Our Ref: TR010031

Application by Highways England for an Order Granting Development Consent for the A1 Birtley to Coal House.

Advice following issue of decision to accept the application for examination

Drawing Title COMPOSITE LAND AND WORKS PLANS
SHEET 2 OF 5
REGULATION 5(2)(i)

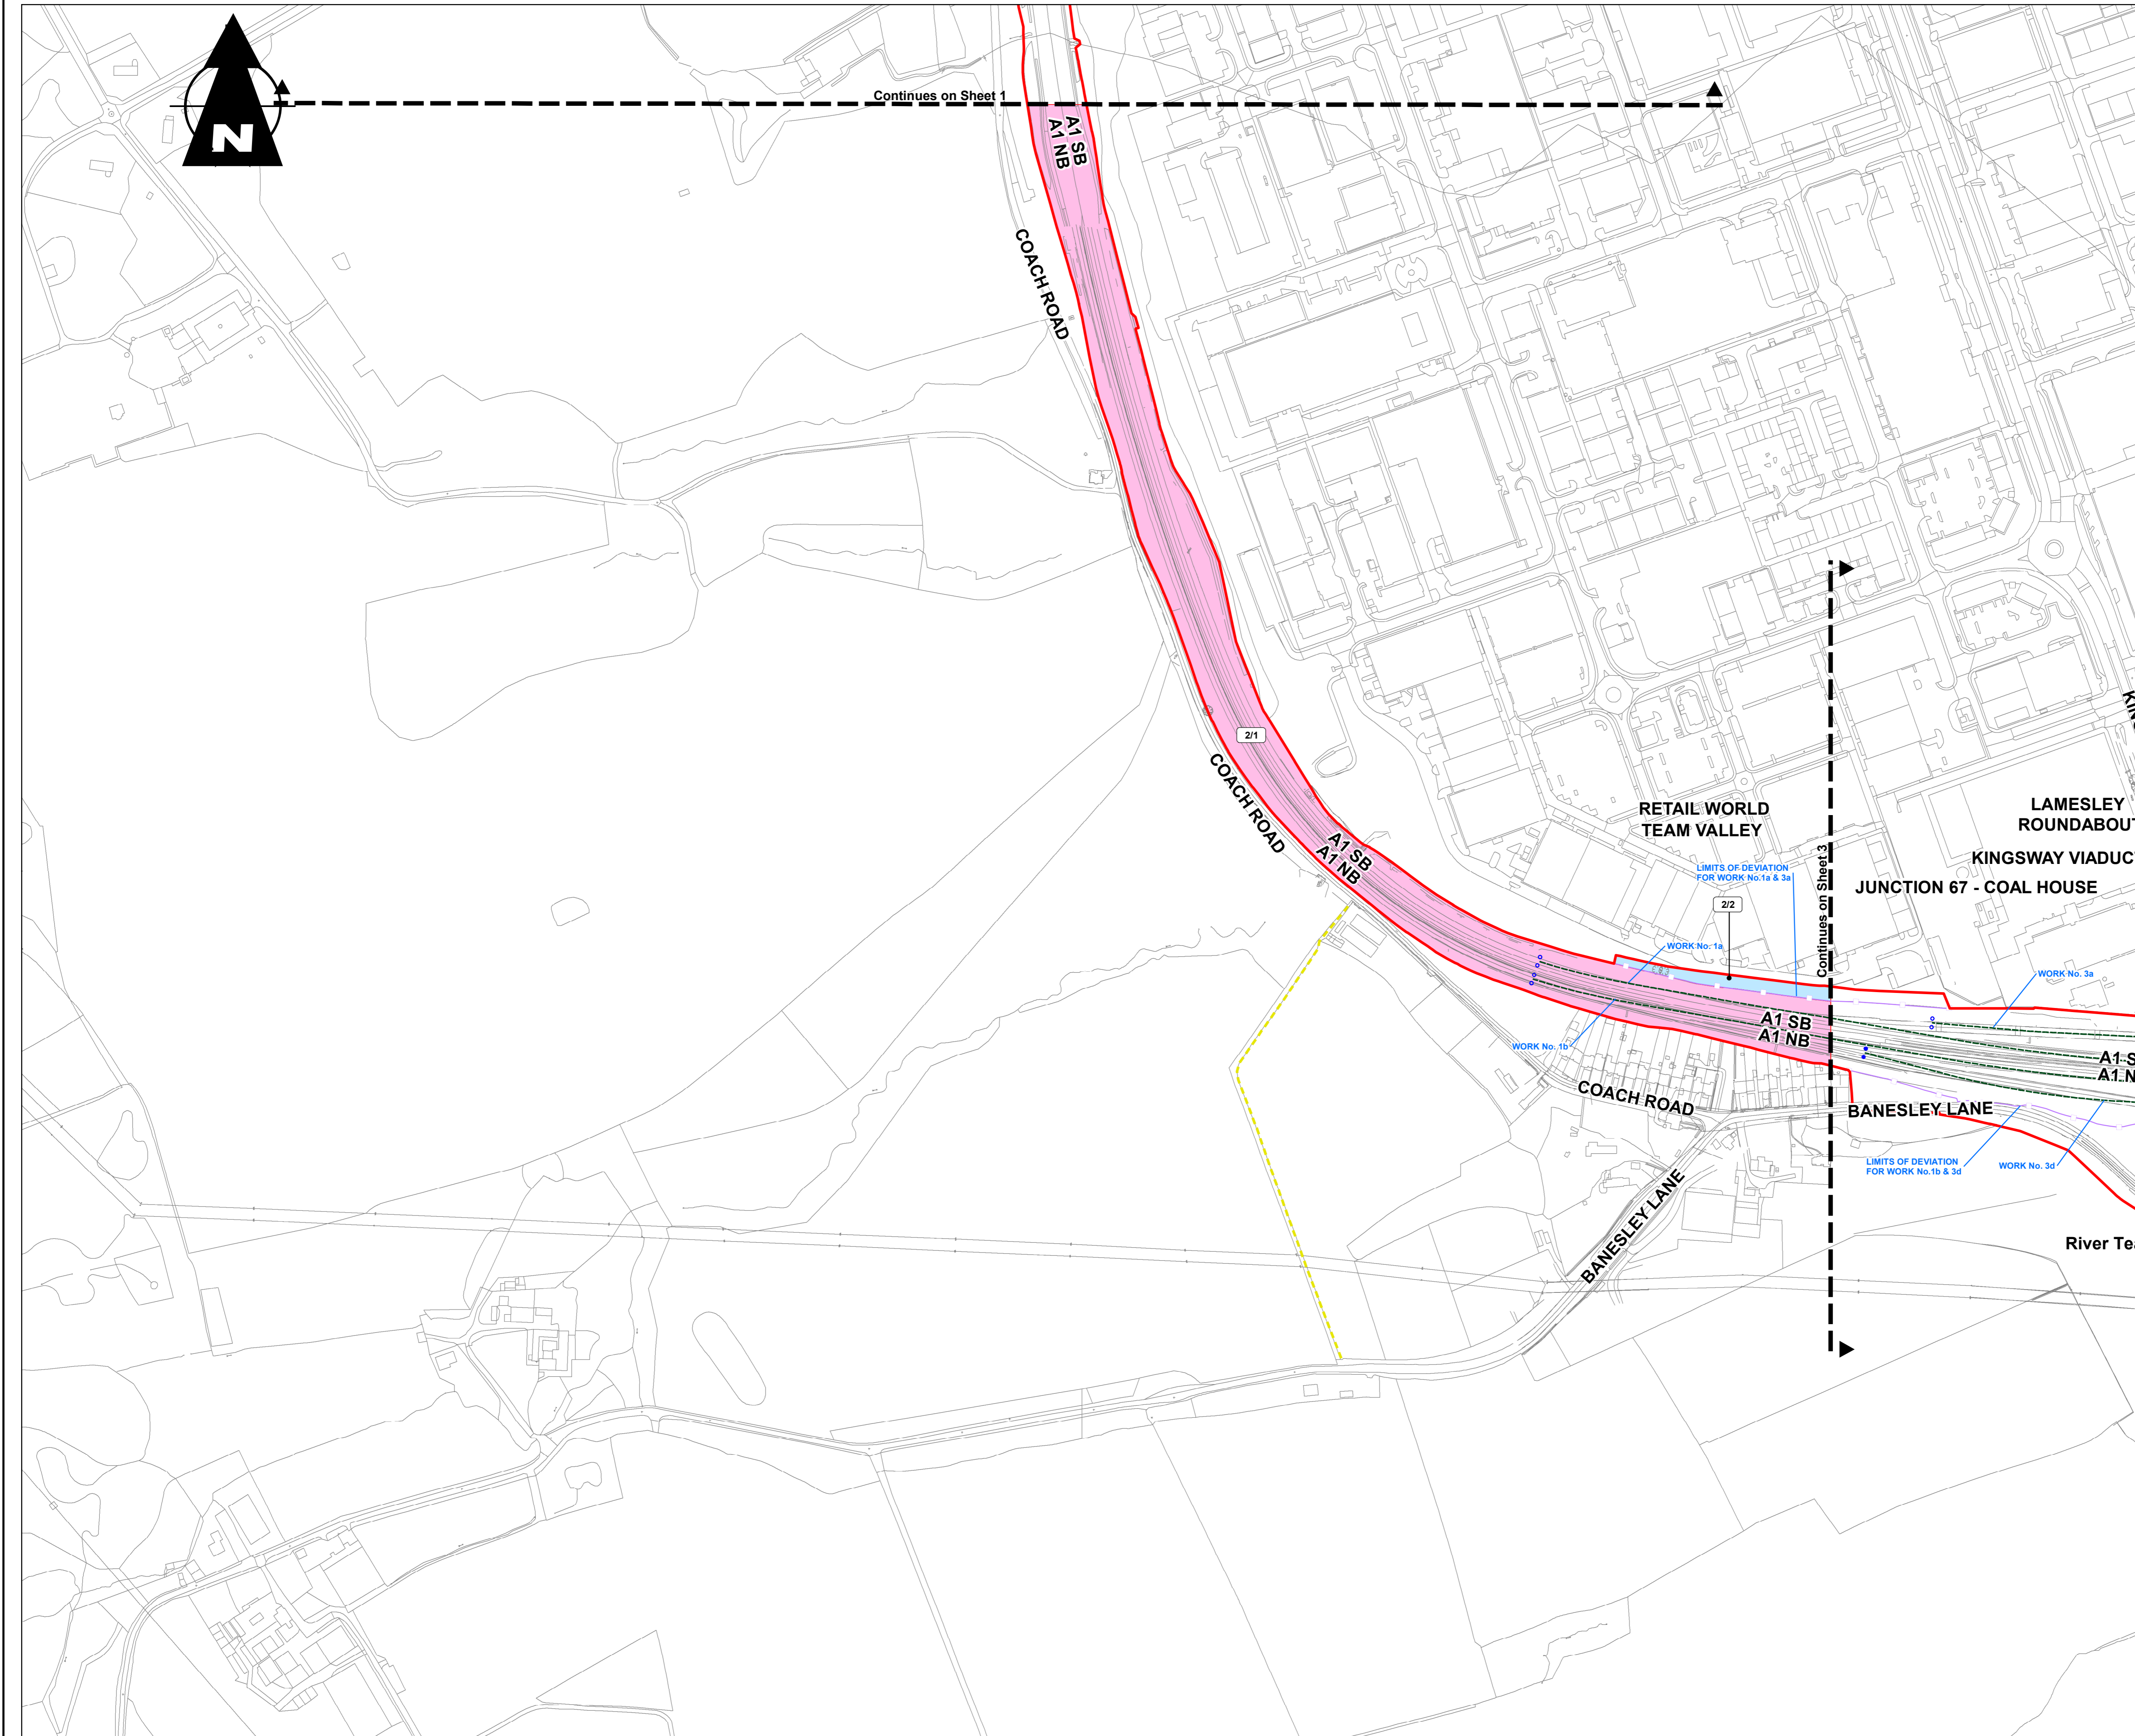
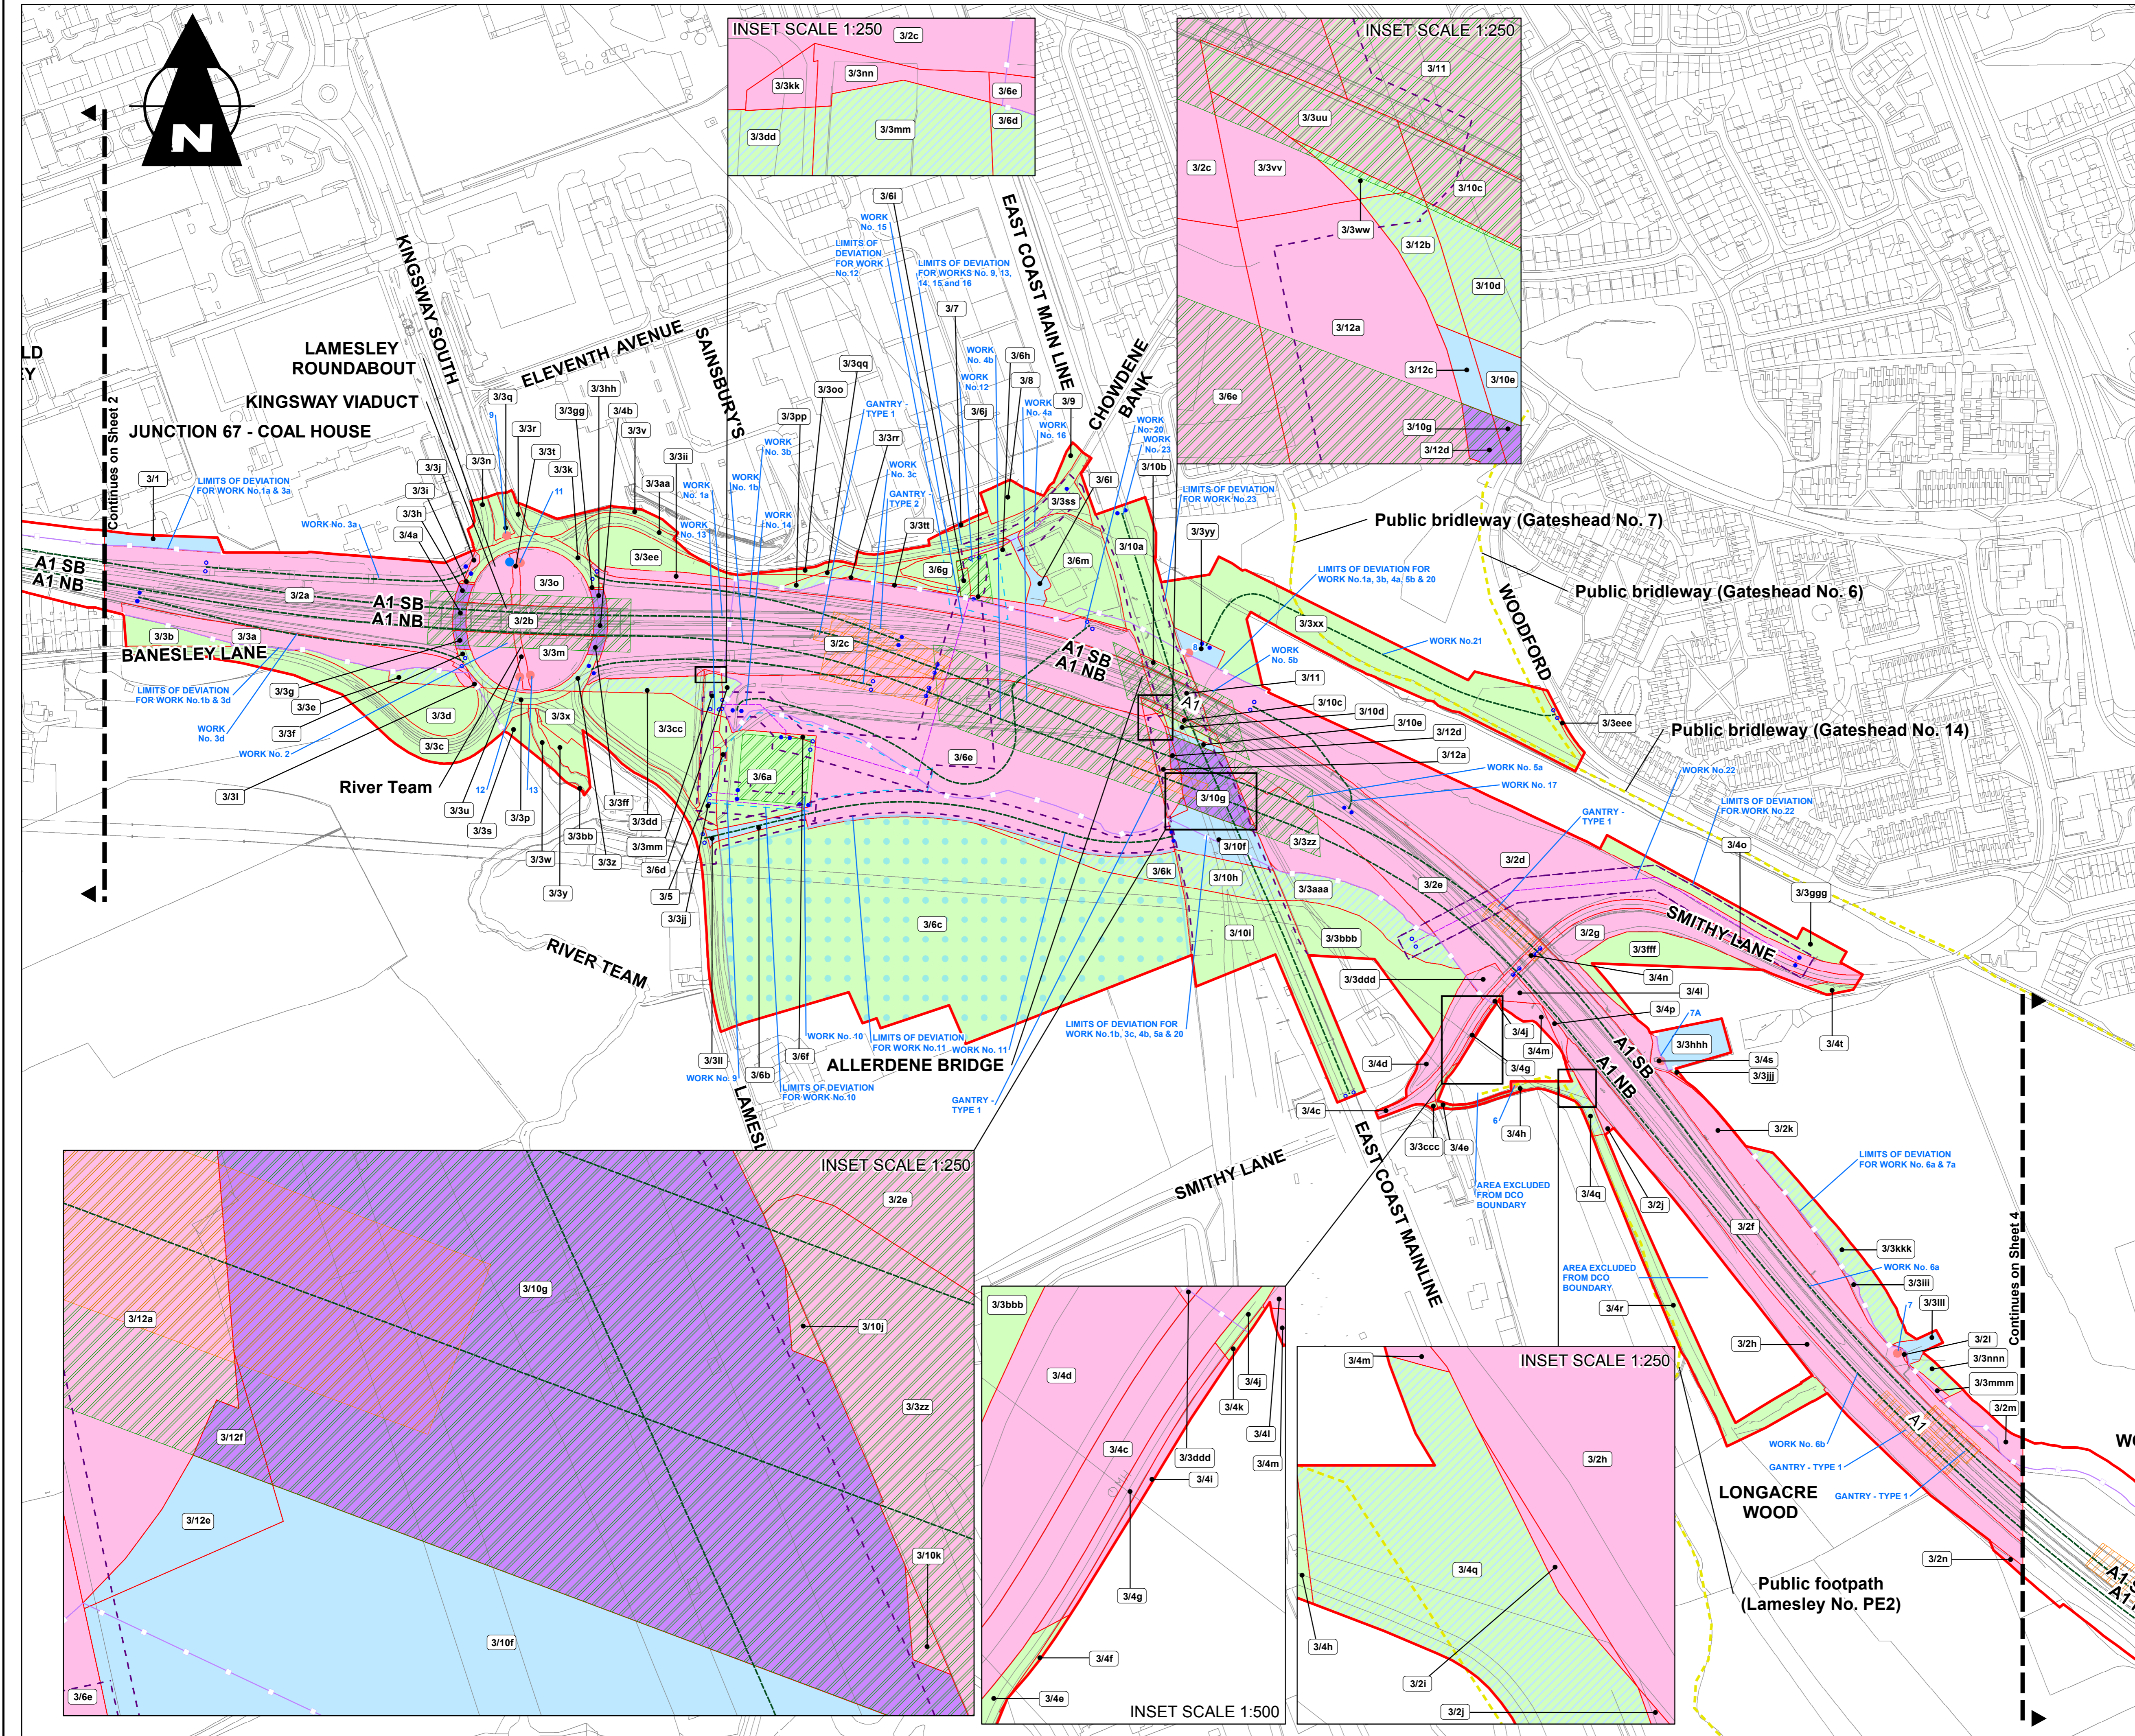
Upon review of the Statement of Reasons and Tables 1 to 6 (Annex A), PINS review of the Works described within these tables and a comparison with the Works and Lands Plan, there appear to be some discrepancies and it would be helpful, if the Applicant could provide a plan or set of plans to show clearly the land plots in relation to the Works.
